## **Necton Parish Council Representation Concerning HVAC versus HVDC Technology for the Vanguard and Boreas Windfarm Connections to the National Grid and Mitigation**

Necton Parish Council (NPC) would like both Vanguard and Boreas Examinations to consider the following representation:

2 April 2020

Indicative Onshore Project Substation
Mitigation Planting - Norfolk Vanguard

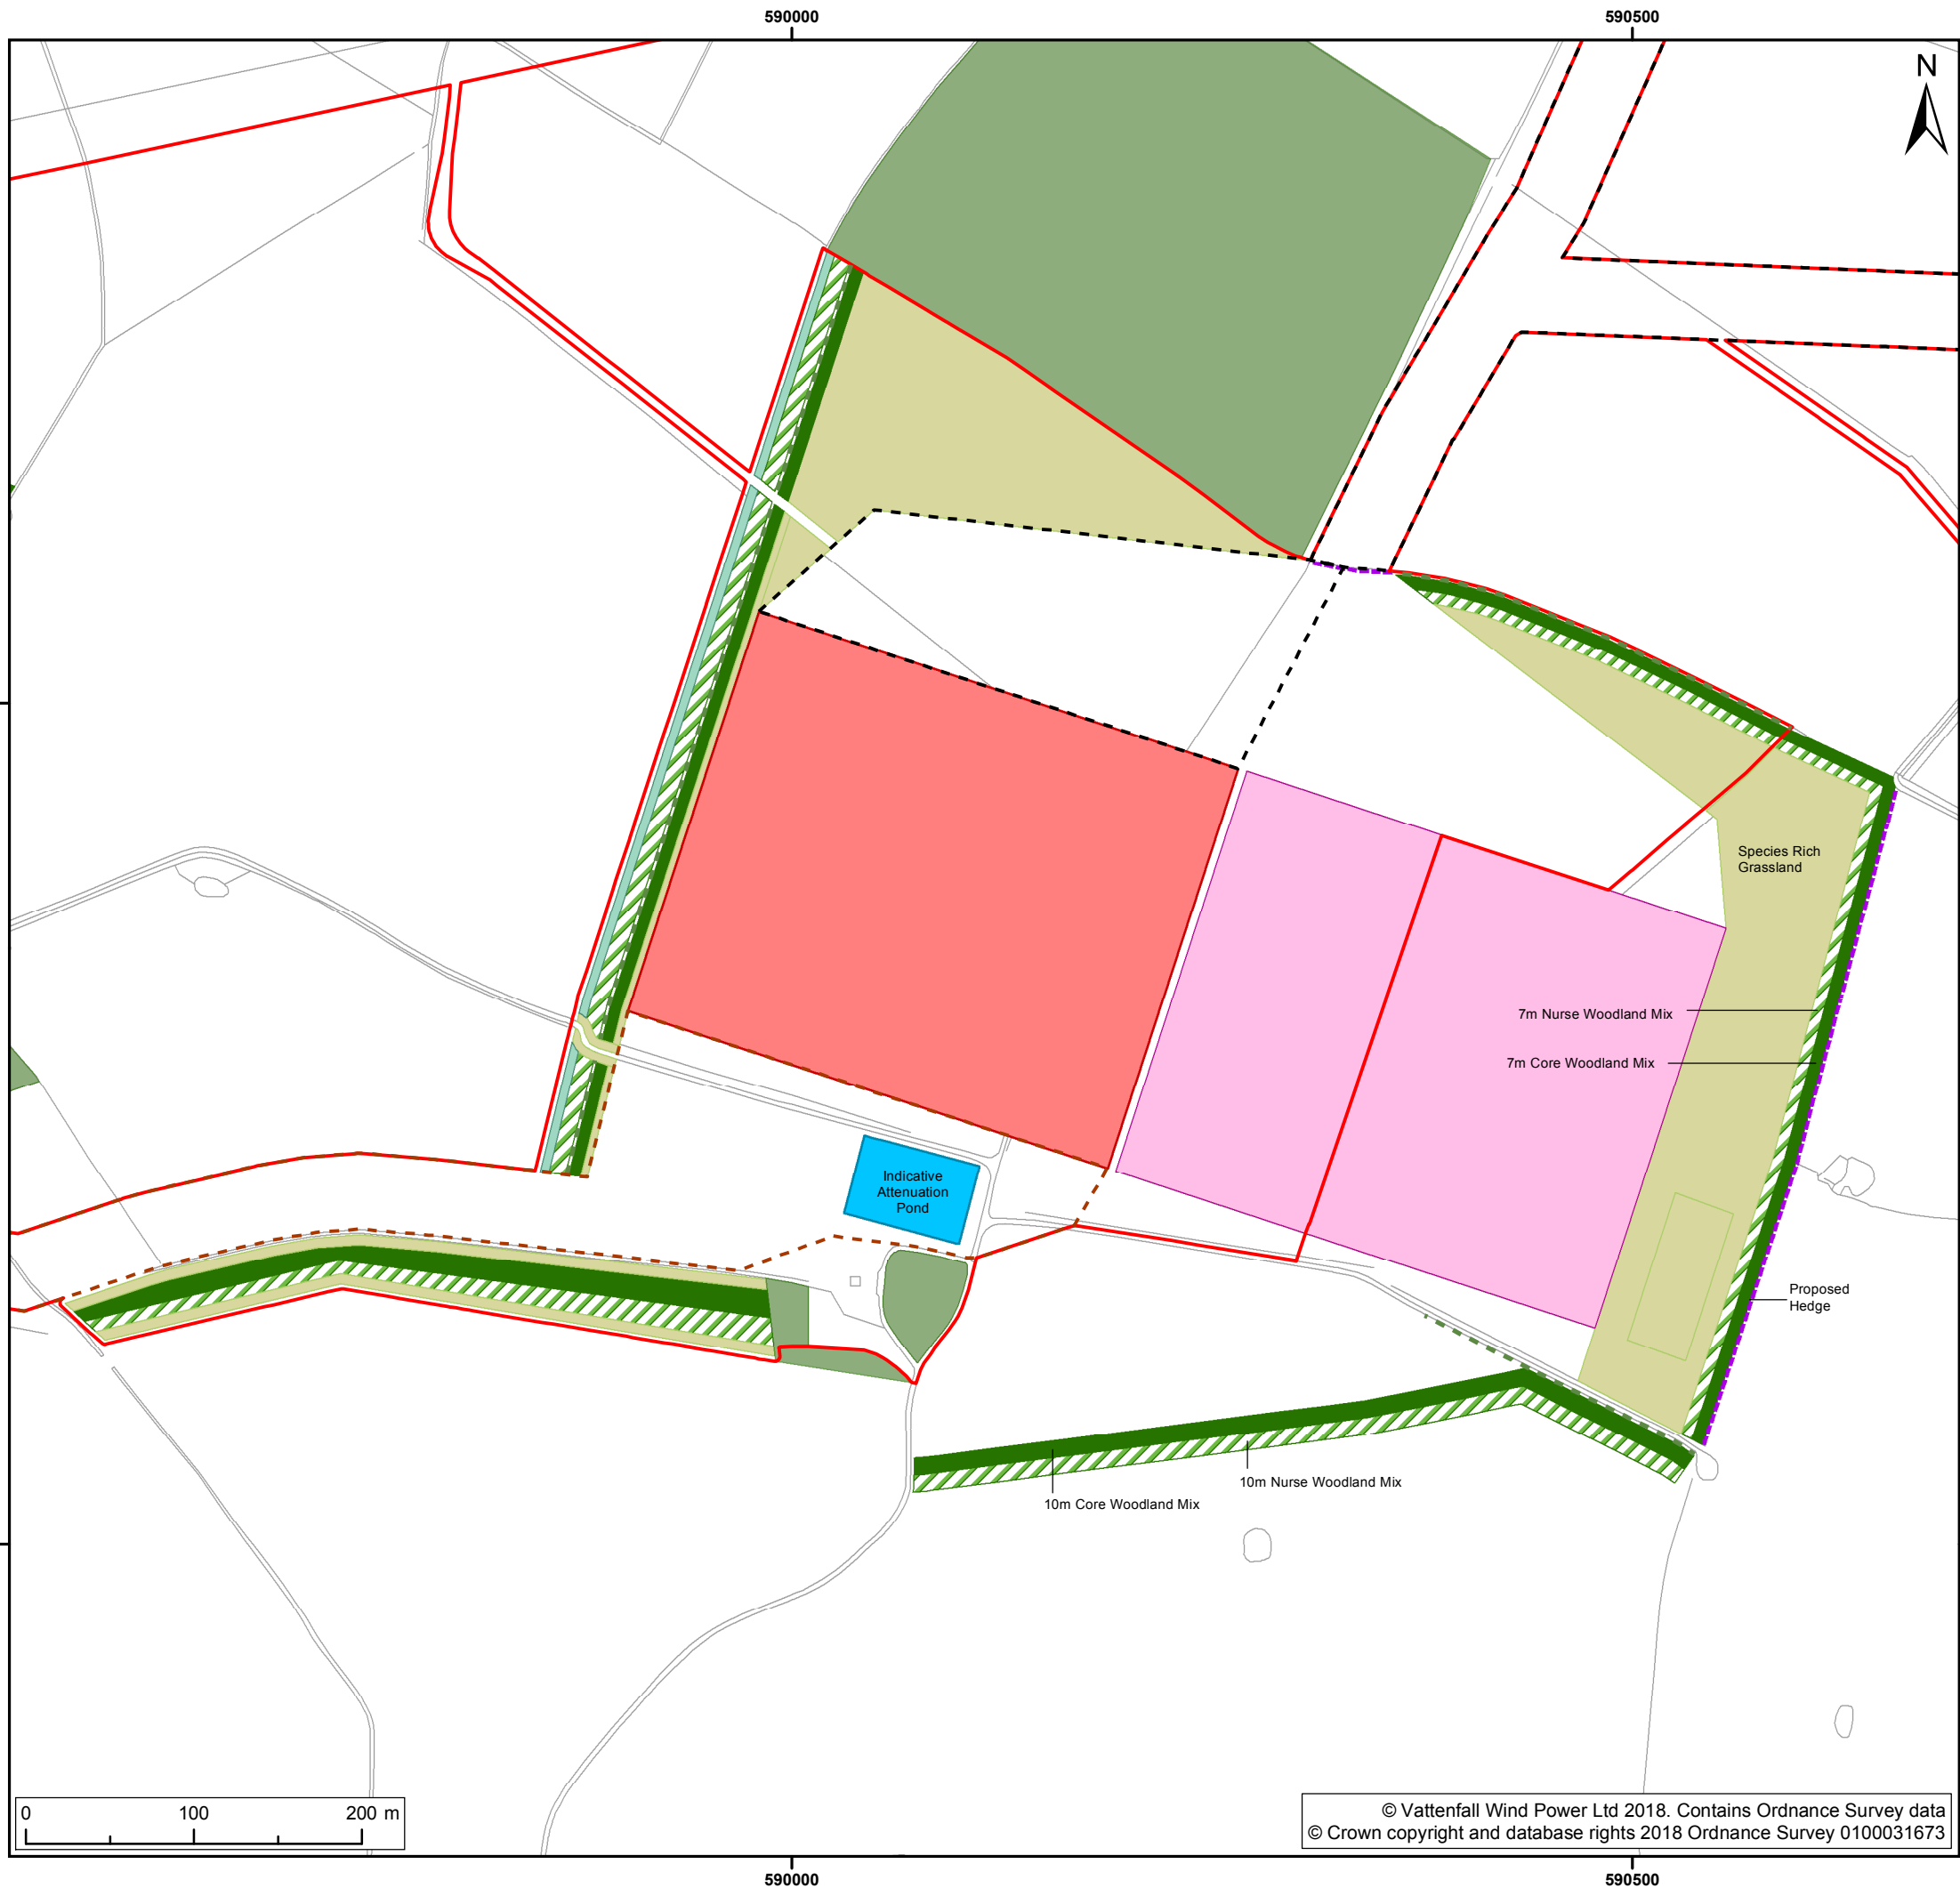
The HVDC option provides a reduction in the area of land impacted for example the reduction in working width along the onshore cable route. Although there is a reduction in the width of the cable route, there is an increase in the area used for the onshore substation in Necton. The cable route is a short-term construction activity that will be made good at the end of the construction period, leaving no visible footprint for the ongoing life of the windfarms. The increase in the footprint of the substations at Necton is not a short-term impact, it will remain for the useful life of the windfarms. The mitigation proposals from Vattenfall only include trees and ‘Subtle Landscaping’ provisions. By this Vattenfall state the

possible, not even required, addition of 1.5 to 2 metre subtle earth banks. Even with fully grown trees this will not mitigate the 19 metre buildings which will stretch up to 25 metres with the masts on top. Necton Parish council have asked for the datum point for land height to be lowered and 10 metre earth banks to be provided (in line with the mitigation installed for the Northern Distributor Road around Norwich). This has not been accepted by Vattenfall, neither is it a requirement from Breckland Council. Therefore, the short-term reduction in width of the cable corridor that will be completely hidden over time is being compared to an increase in acreage and height for the Necton substations that will not be mitigated during the life of the windfarms. This does not appear to be an equitable trade-off and NPC questions this aspect of the overall benefit of the decision.
